CITY OF ALBUQUERQUE

**Re: Weeping Willow Plaza
5001 Central Ave NE
Request for Permanent C.O. - Accepted
Engineer's Stamp dated: 12-16-14 (K17D107)
Certification dated: 12-22-14**

**Re: Weeping Willow Plaza, 5001 Central Ave.
Certificate of Occupancy – Transportation Development**
Architect's Stamp dated 10-25-13 (K17-D107)
Certification dated 12-30-14

C0.1
GRADING PLAN

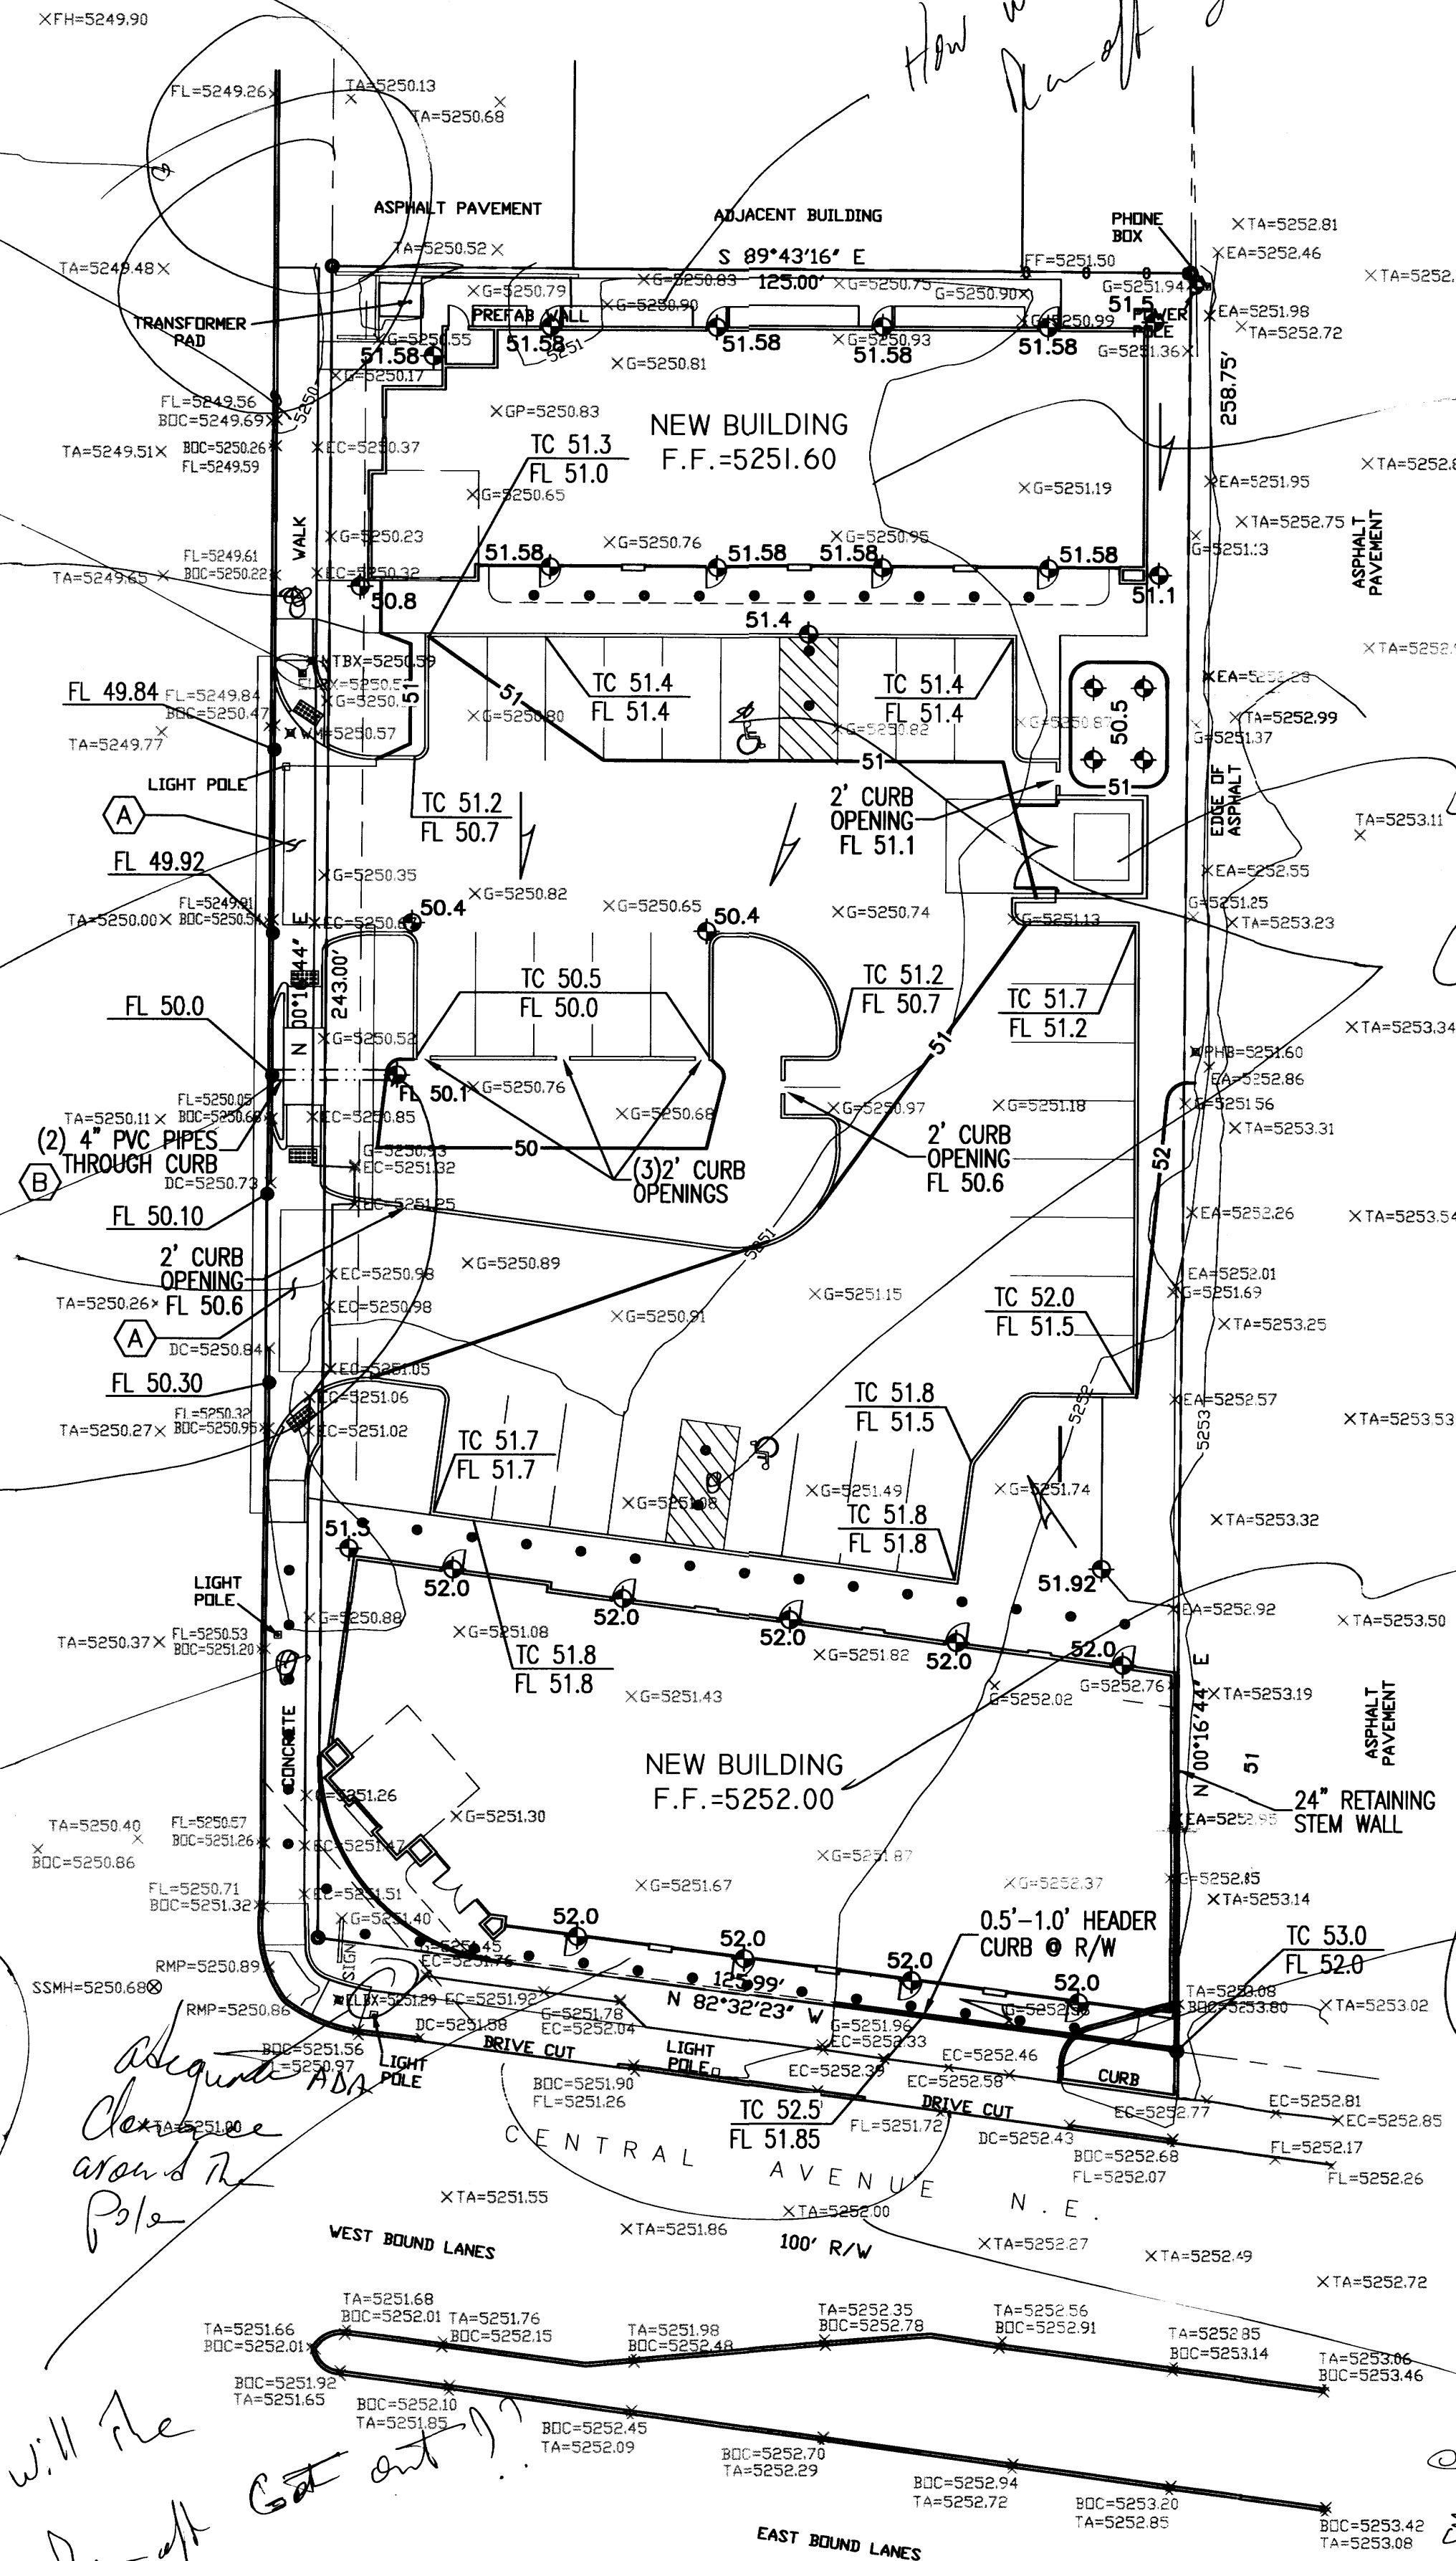
- Are there offsite runoff from the east and the north? How will offsite runoff drain through the site? The southerly building might be blocking offsite runoff.

- The existing entrances not being used have to be removed and replaced with standard curb and gutter. Portion of the existing entrance at the northwest corner of the site will have to be removed. Provide back sidewalk elevations and how they will tie to the proposed doorways. Will all doors be handicap accessible?

- Include roof flow directions. How will the runoff drain north side of the northerly building and south side of the southerly building? There are 2-4" pipe penetration proposed. Will the runoff flow over the sidewalk if the pipes are plugged? Provide more elevations in this area and back of sidewalks along Jackson Street. Will the existing pipe penetration along Jackson Street be removed?

- Do we have adequate water block at the entrances?
- Provide spot elevations within the handicap parking area to assure ADA compliance.
- A drain to the sanitary sewer should be provided for the trash enclosure area if a restaurant is being proposed on this site.

- Clearly show existing versus proposed improvements along the right-of-way.

1. Offsite flows are quantified and discussed in the revised plan drainage narrative.
2. All existing driveways are noted as being removed and replaced with curb/gutter and sidewalk. Additional sidewalk elevations have been added and all proposed doors are accessible.
3. Roof drain locations have been added. An overflow discussion has been added to indicate that flow will exit via the north driveway if drain lines were to become blocked.
4. More spot elevations have been added to indicate adequate water blocks.
5. Parking spot elevations have been added to ensure ADA compliance.
6. Refuse area drain is shown on the Plumbing sheets in the Building Permit sets.
7. Drafting revisions indicate proposed improvements more clearly.

date: 05-15-14 drawn: ejs
rev.:
C0.1
GRADING PLAN

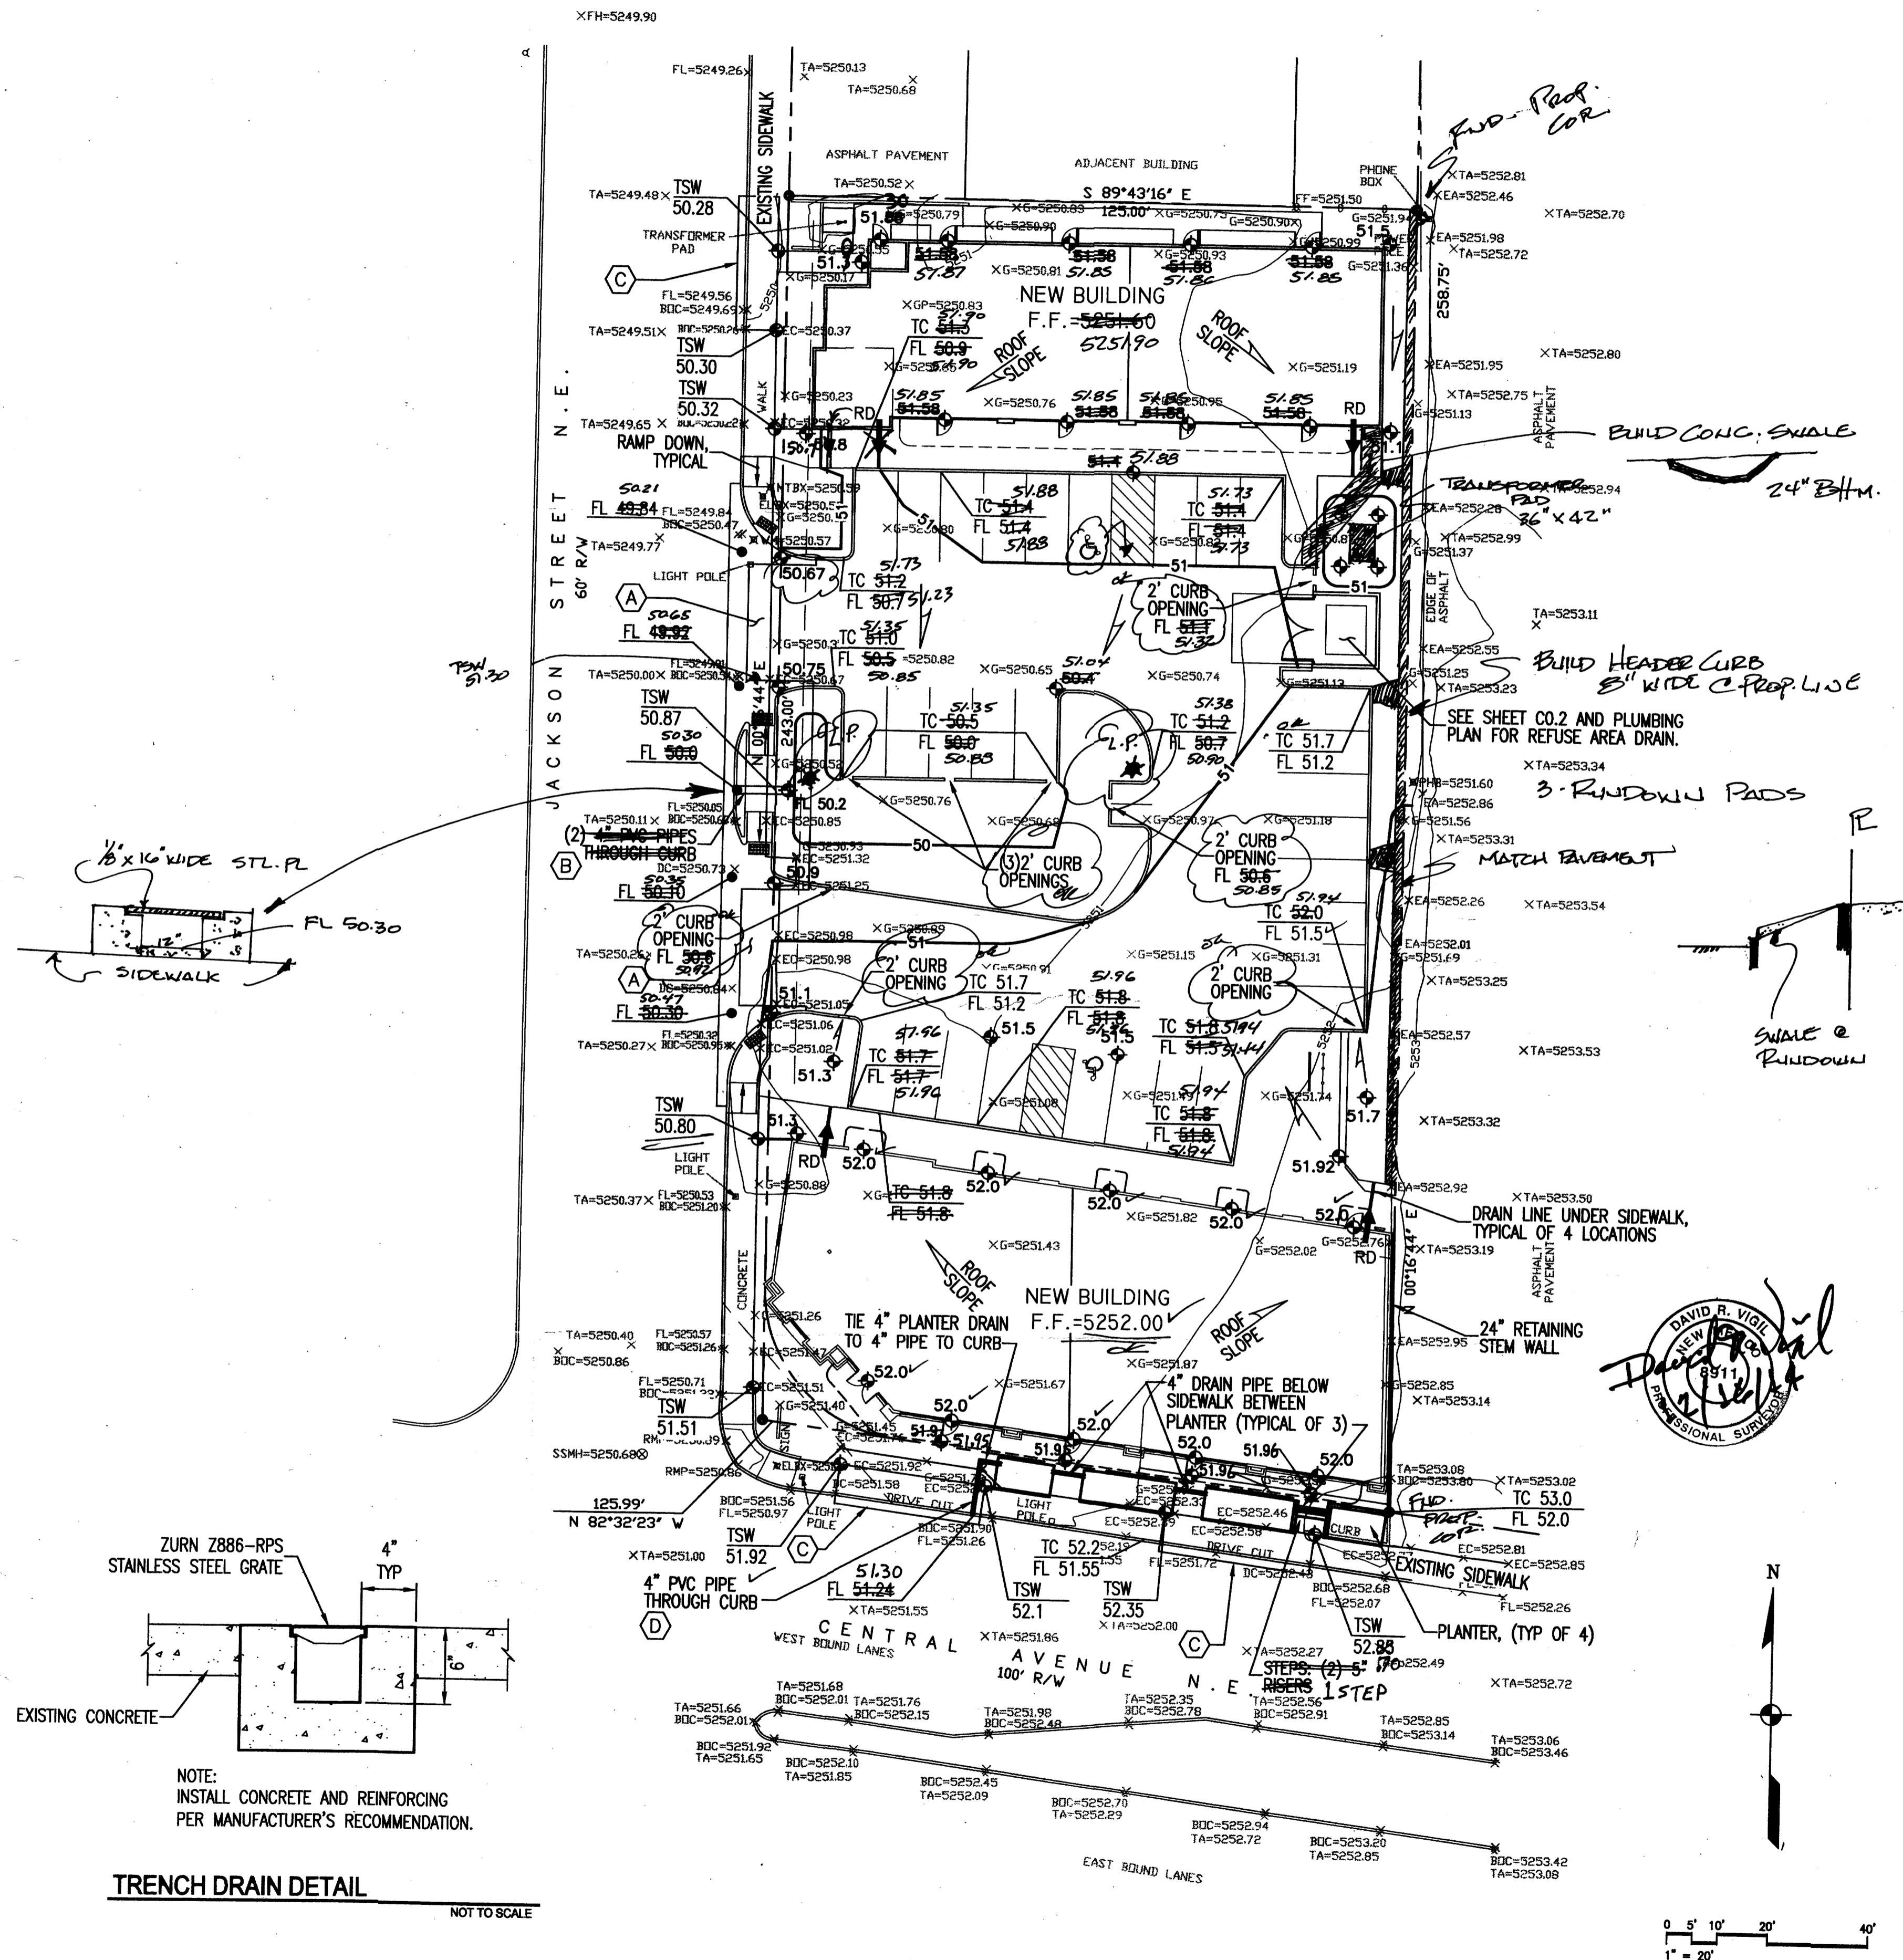
Did not Remove Curb section
And NO Rebar

This is a 12" Culvert plan calls
for 2-4" p.u.e. ? it can work if they
saw cut cold joints for expansion material
and Tac Weld Bolts

No expansion in Curb
Need To Remove
and Replace to City Dwg 2235

North side pipe on Central

12/30/14 Spoke with Jason Rodriguez about site. He states that these areas have not
been fixed. will wait for Jason to call when fixed.
[Signature]

Hi Curtis I was just by this project I have a plan but no letter (Nov.2013) where the culvert is it shows two 4" PVC pipes and the south side drain was not built to City of Albuquerque DWG.2235 let me know if you won't me to make contact with the contractor thanks.
